24 March 2020

Anthony Ko
Team Leader, Energy Assessments
Department of Planning, Industry and Environment
4 Parramatta Square, 12 Darcy Street
Parramatta NSW 2150

Re: Snowy 2.0 Main Works - Preferred Infrastructure Report - Response to request

Snowy 2.0
Main Works
Figure 2.13

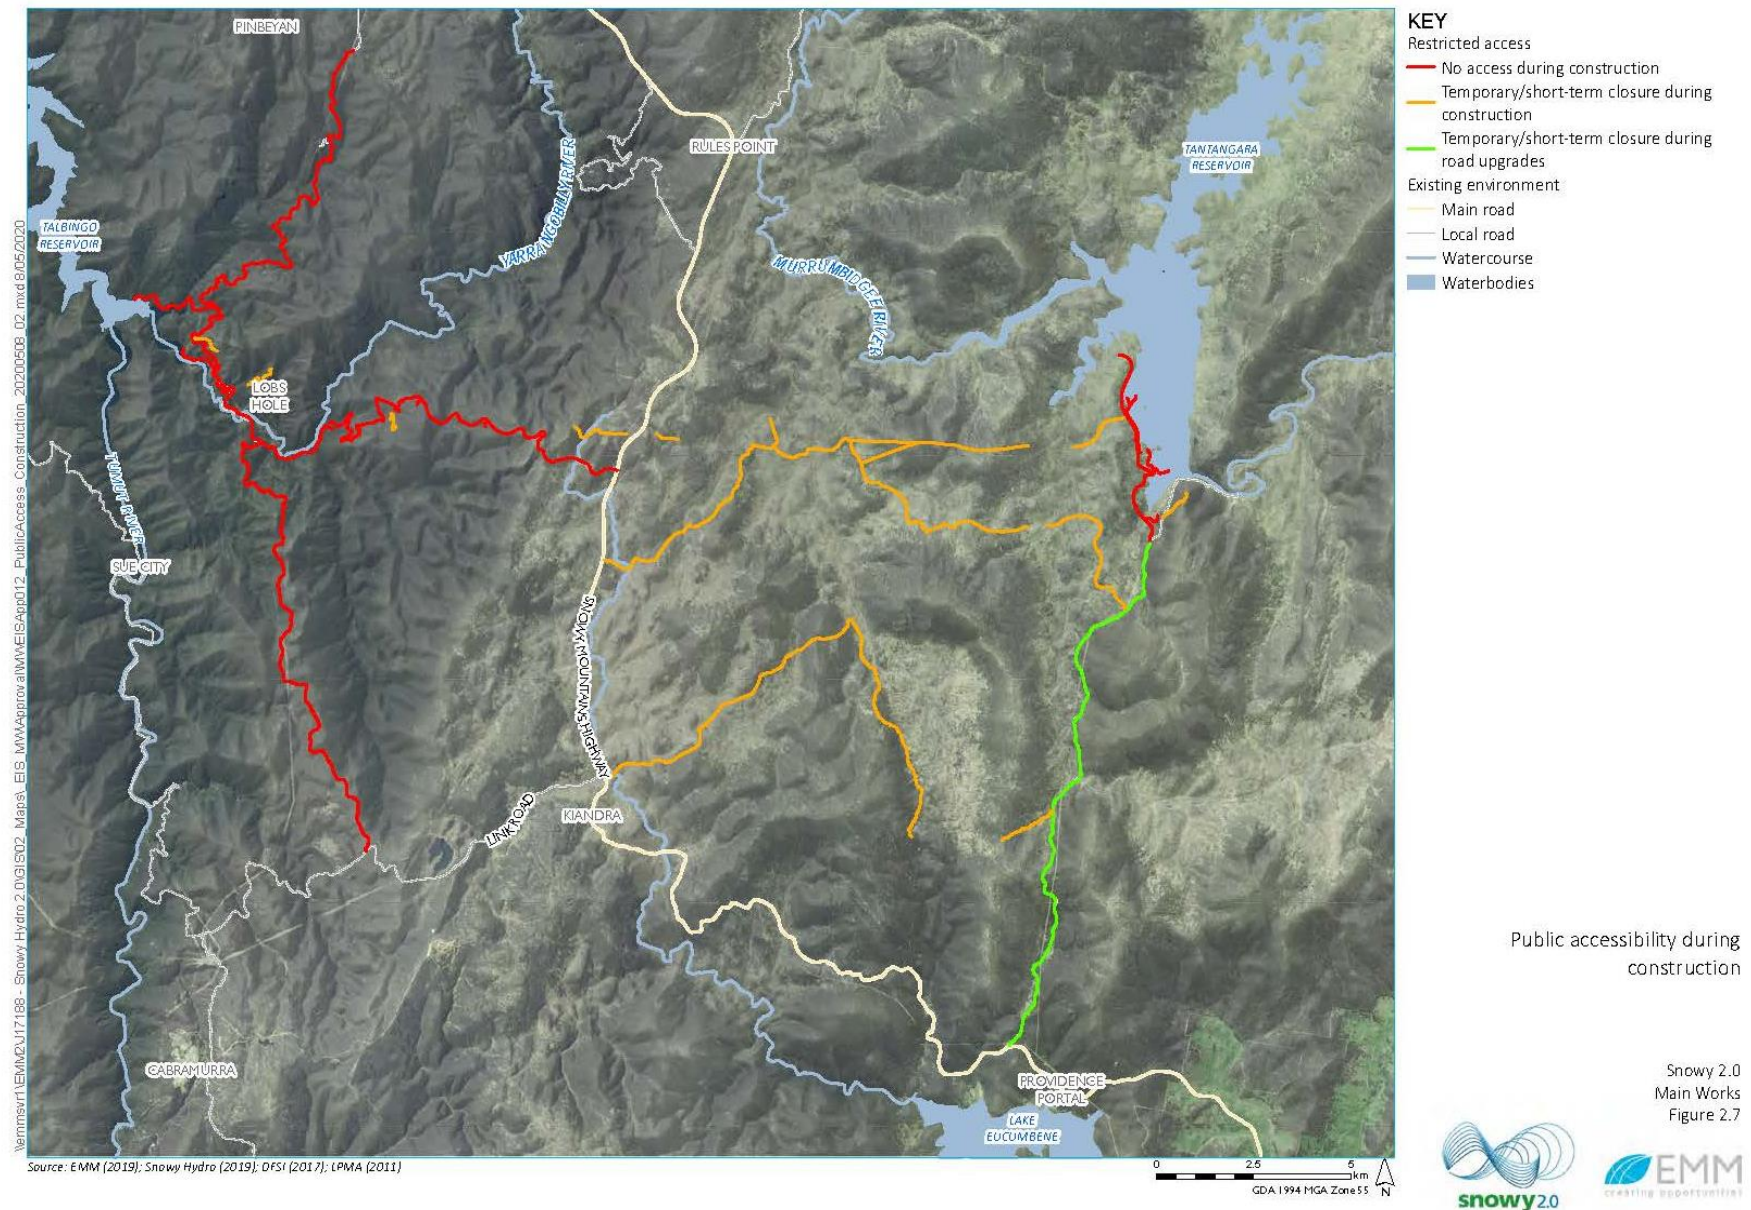
Predicted noise impacts of Rock Forest excavated rock emplacement to residence on 6560 Snowy Mountains Highway, Adaminaby opposite the Rock Forest site. The PIR did not re-evaluate the noise impacts from the revised rock emplacement strategy which now includes spoil disposal at Rock Forest, so presumably the increases will be higher.

Outline the approach Snowy Hydro are proposing to mitigate impacts and detail any consultation that has occurred or is planned with the landowner.

The EIS predicted construction noise levels for this residence (R6) of 51.2-53.6dBA – an exceedance of 11-14dB - under calm and adverse conditions.

Construction noise modelling was completed for the proposed Rock Forest construction activities including proposed excavated rock emplacement. The construction noise modelling found that noise levels for R6 are predicted to marginally increase by less than <0.5 dB and remain controlled by logistics/laydown activities modelled for EIS.

As outlined in the proposed mitigation measure NV02 (see Appendix B), affected landholders at R6 will be consulted prior to and during construction and will be notified of proposed mitigation measures that will be used to manage construction noise levels to below Interim Construction Noise Guideline (EPA 2009) NMLs where practicable.
